Application for Planning Permission for Works or Extension to a Dwelling

Development: Single storey rear extension, loft conversion with rear dormer and rooflights to front, alterations to fenestration and removal of chimney stack.
Location: 5 Vernon Close Rustington BN16 2NR

1:500 Proposed Block Plan

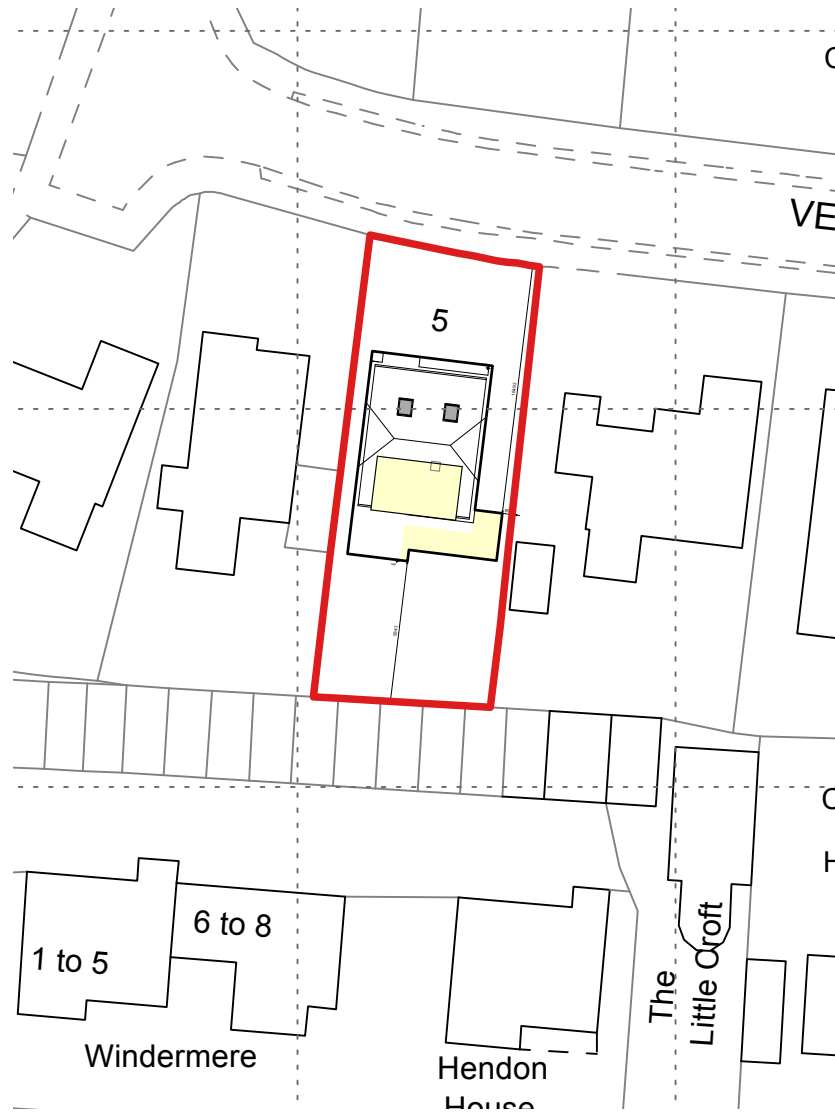
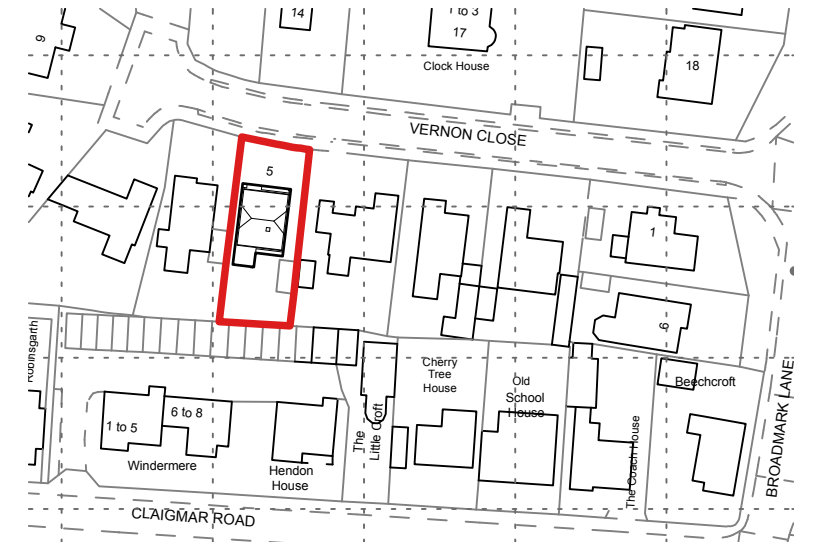
Block Plan

Please include the dimensions from the proposed extension to the site boundaries on your proposed block plan.
